Department of Planning and Environment

OUT22/1216

**Wallerawang Battery Energy Storage System (SSD-14540514)  
Environmental Impact Statement (EIS)**

# Detailed advice to DPE Planning & Assessment regarding the Wallerawang Battery Energy Storage System (SSD-14540514) EIS

APPENDIX B SITE POST-DEVELOPMENT LAYOUT

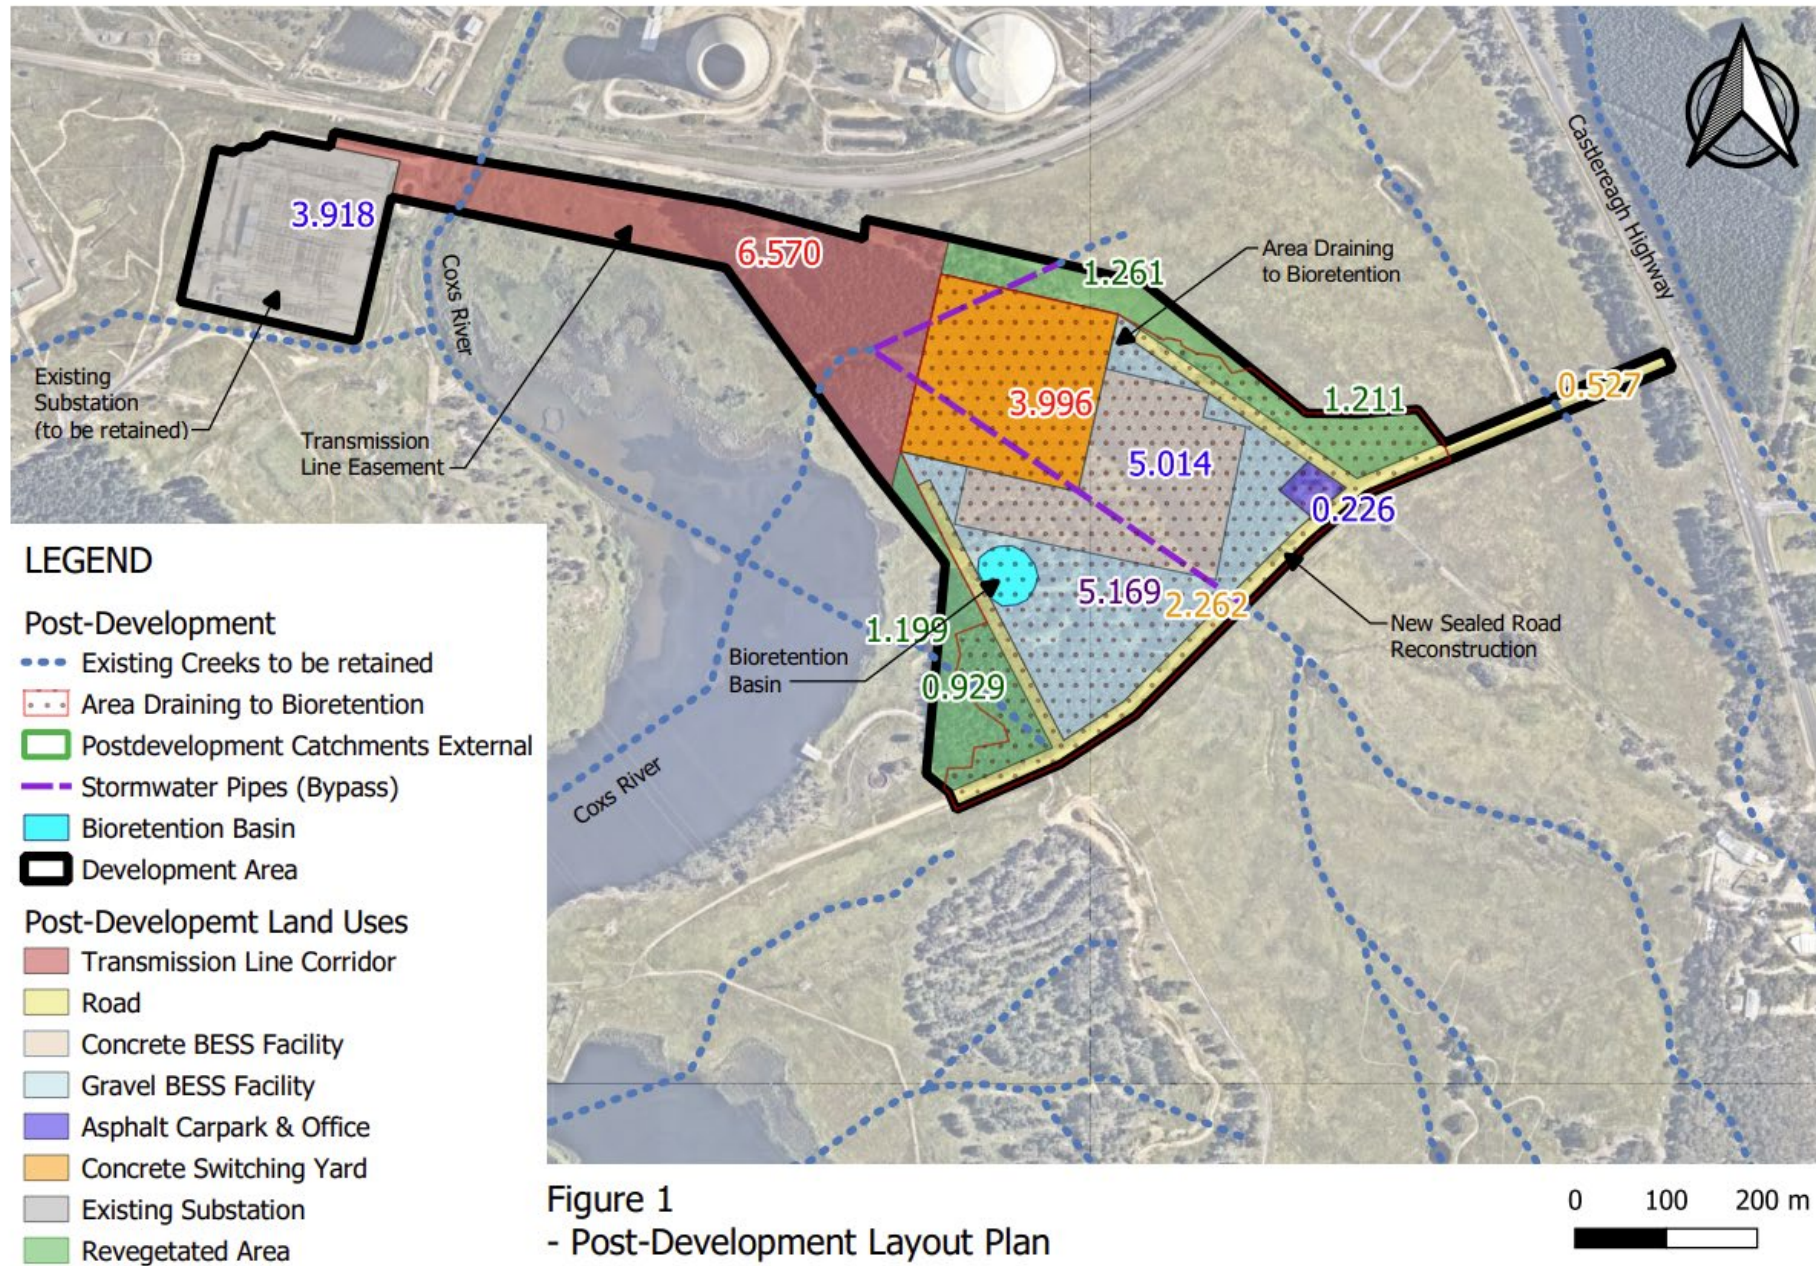
### 3.1 Recommendation – Prior to Determination

- The proponent should review the bioretention basin to ensure either; 1) its capacity is within the Maximum Harvestable Rights Dam Capacity for the property, or 2) that it satisfies a relevant exemption in Schedule 1, *Water Management (General) Regulation 2018*.

- The stormwater management design should consider separation of clean and dirty water runoff.

The proposed bioretention basin will capture runoff from the development site and potentially from clean runoff areas. Separation of clean and dirty water should be incorporated into the stormwater management design.

It is unclear whether the basin is sized within the Maximum Harvestable Rights Dam Capacity (MHRDC) for the property or whether it satisfies a relevant water licensing exemption in Schedule 1, *Water Management (General) Regulation 2018*.
